Reference: 21.615r03v02

Re: Project Francis – The Star
Response to Request for Information

We refer to the subject property and proposed residential development. TRAFFIX has been forwarded comments from Department of Planning and Environment concerning the Construction Traffic Management Plan.

A

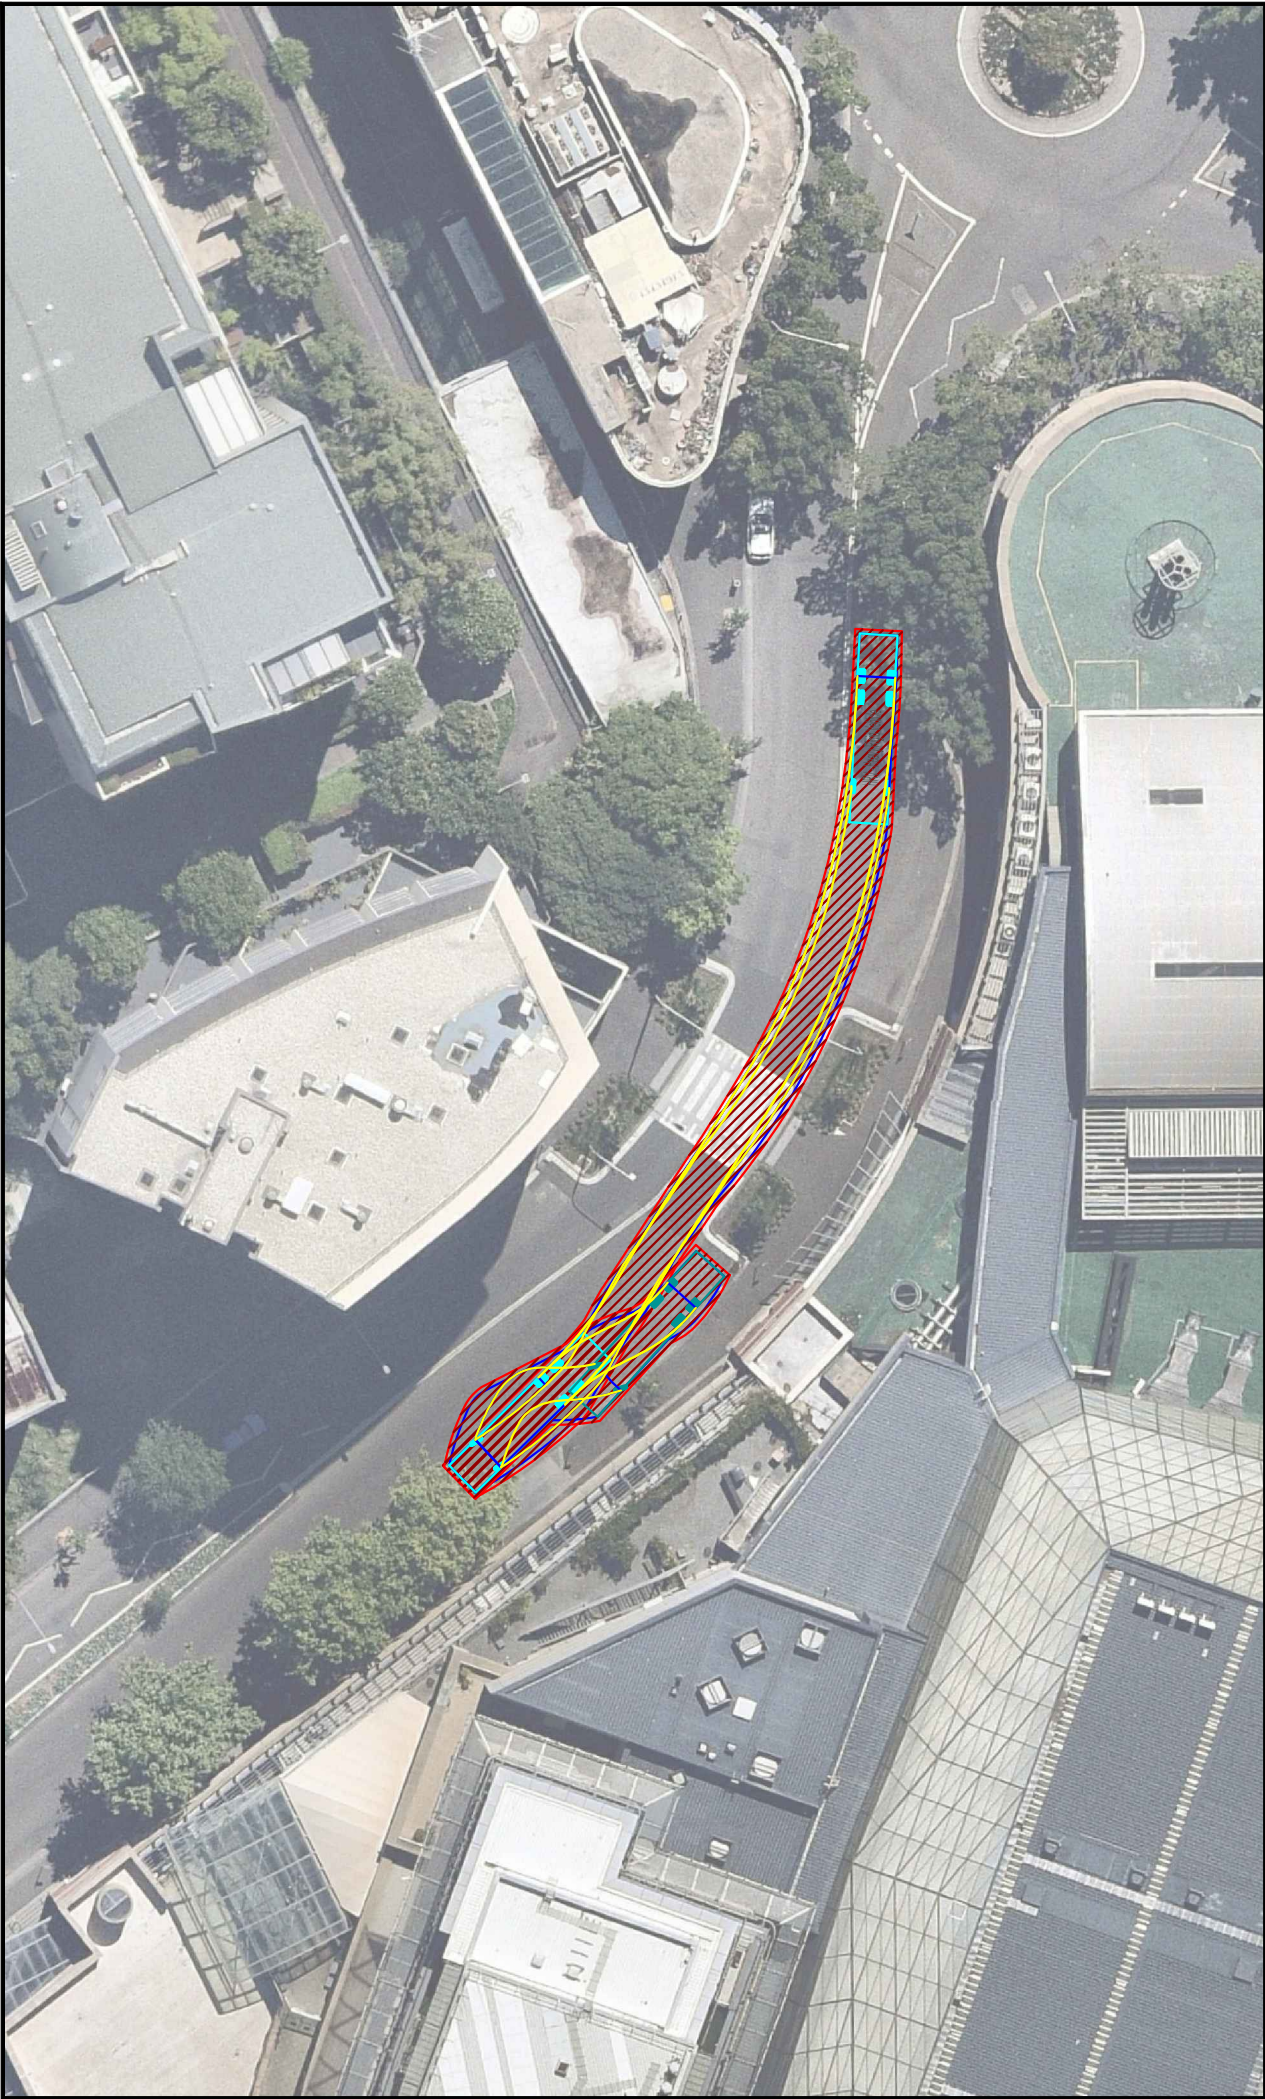
- Clarify how 20m articulated vehicles would be managed during construction and provide further swept path analysis from the proposed work zones to confirm they will not interfere with traffic on Jones Bay Road.

The 20m articulated vehicles (AVs) will be subject to individual applications to Council for access to the existing loading dock within The Star. This is to comply with Council's standard requirements as provided in Appendix A of the CTMP. As such the CTMP does not refer to the AVs as separate applications will be prepared for these movements with the relevant swept path analysis. It should also be noted that the AVs were not to access the works zone on Jones Bay Road and only the existing loading dock for The Star. Therefore, the CTMP is considered sufficient to address the majority of construction vehicles and the AVs will be subjected to separate applications to Council in accordance with their standard CTMP requirements.
